Application No: 20/00918/DISC

Proposal: Discharge of condition 55 (parking strategy) of 10/01642/OUT

Location: Heyford Park, Camp road, Upper Heyford, Bicester, OX25 5HD

Transport Development Control

Figure 1-1 - Village Centre North and Phase 1 Village Centre South Layout Plan

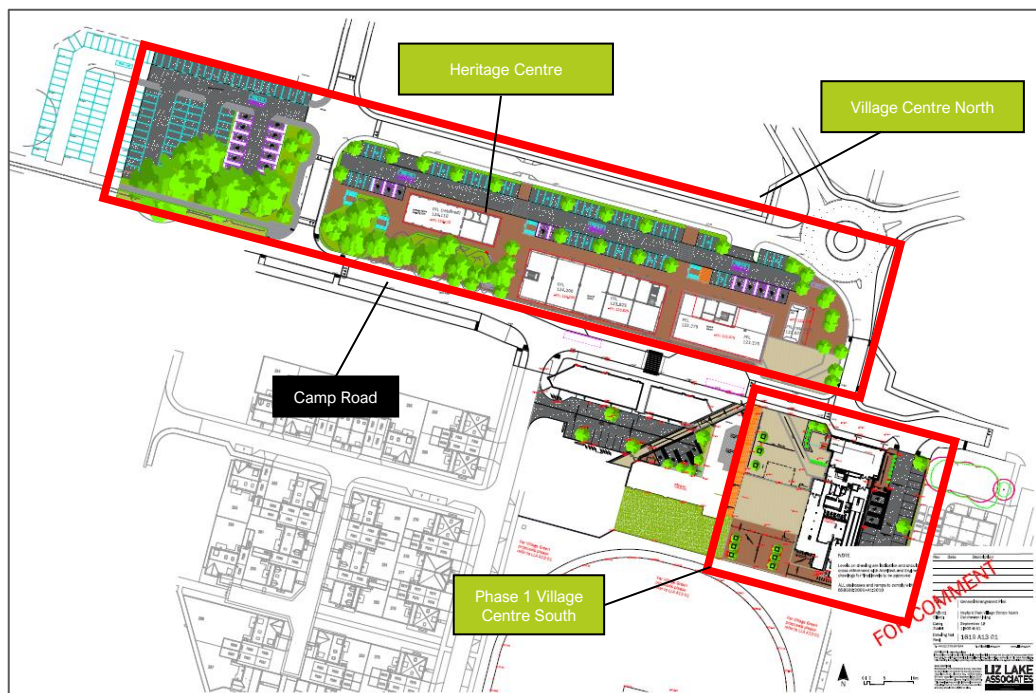
- Paragraph 1.1.1 states that this application is in discharge of a condition of planning permission 18/00043/NMA, whereas it is actually in discharge of planning permission 16/01000/F.
- Figure 1-1 would benefit from showing the Heritage Centre as well since the CPMP covers this facility. **Reason for objection.**
- Paragraph 1.2.1 states that the jurisdiction of the CPMP is *“North and South sections of Village Centre”* this would benefit from being clarified as *“...as shown in Figure 1-1”*

Graph 3-1 Summary of Weekday Parking Accumulations

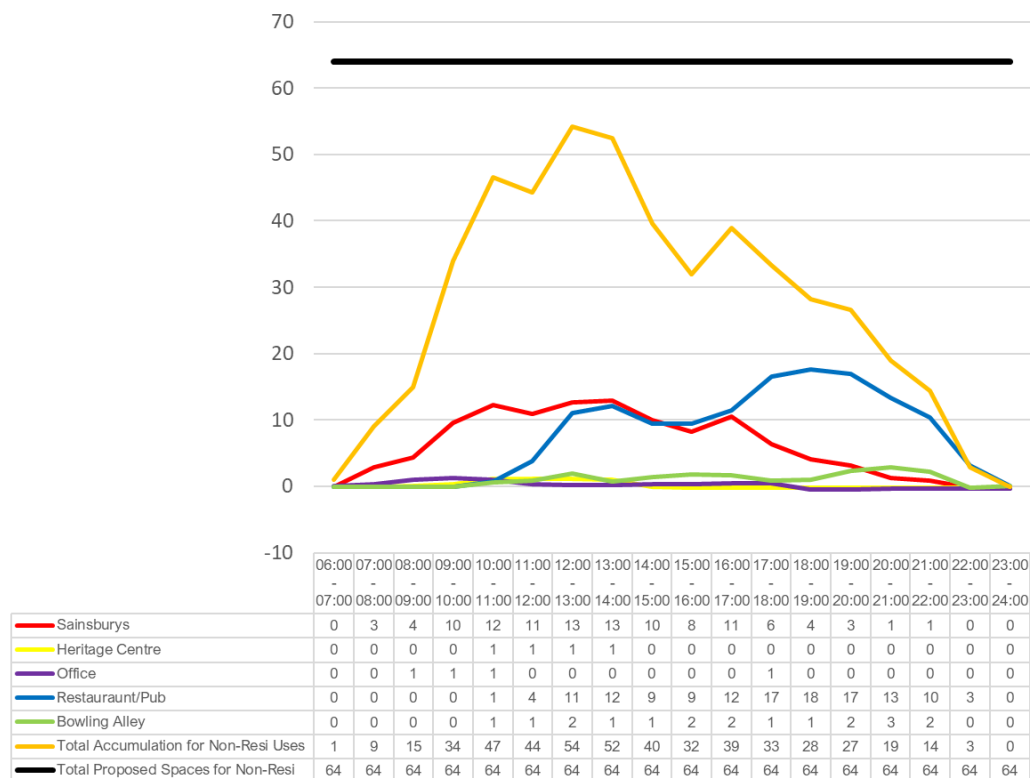
- Paragraph 3.6.8 implies that the total parking provision will be 102 spaces. This based on 40 spaces for the residential portion of the development as dictated by standards and 62 spaces for the non-residential uses based on a parking accumulation analysis. This level of provision is considered inadequate because it is likely that there will be occasions when the accumulated demand for non-residential uses will be exceeded. Some additional provision to accommodate this is therefore required. **Reason for objection.**

Figure 3-3 - Car Parking Allocation

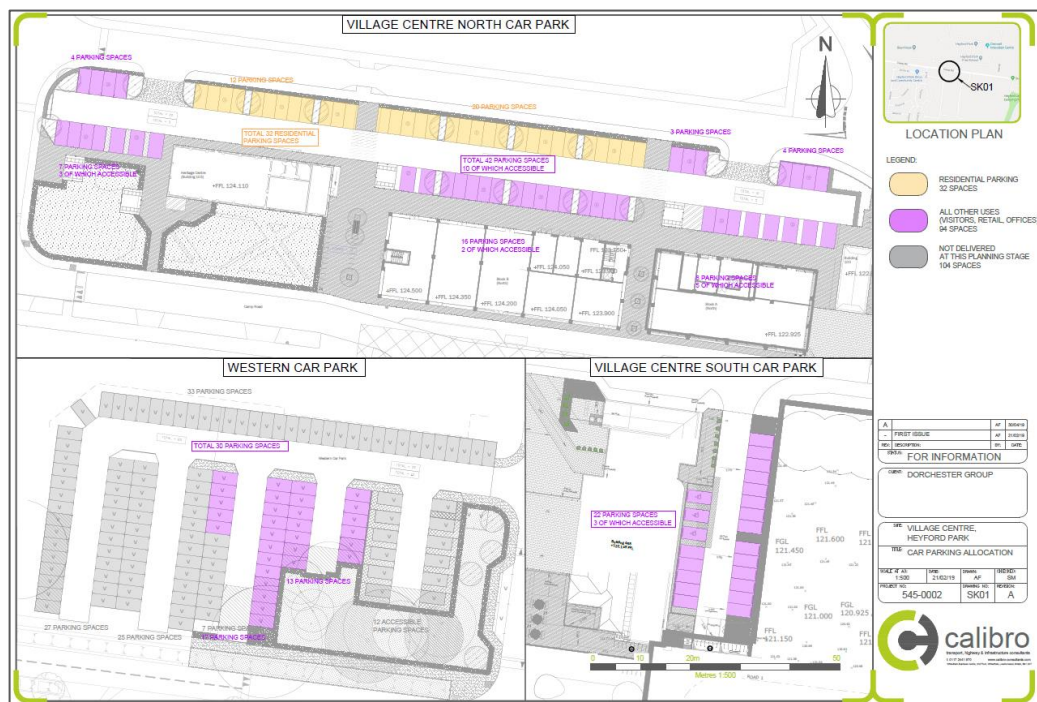
- Figure 3-3 appears to show a total allocation of some 126 car parking spaces. It is assumed that these include spaces to serve the heritage centre, although it is not clear how many. The County requires a clear statement of how many parking spaces are managed by this CPMP, and the use for which they are intended. As noted above the total number of car parking spaces will need to provide for occasions when the accumulated demand for non-residential uses will be exceeded. **Reason for objection.**
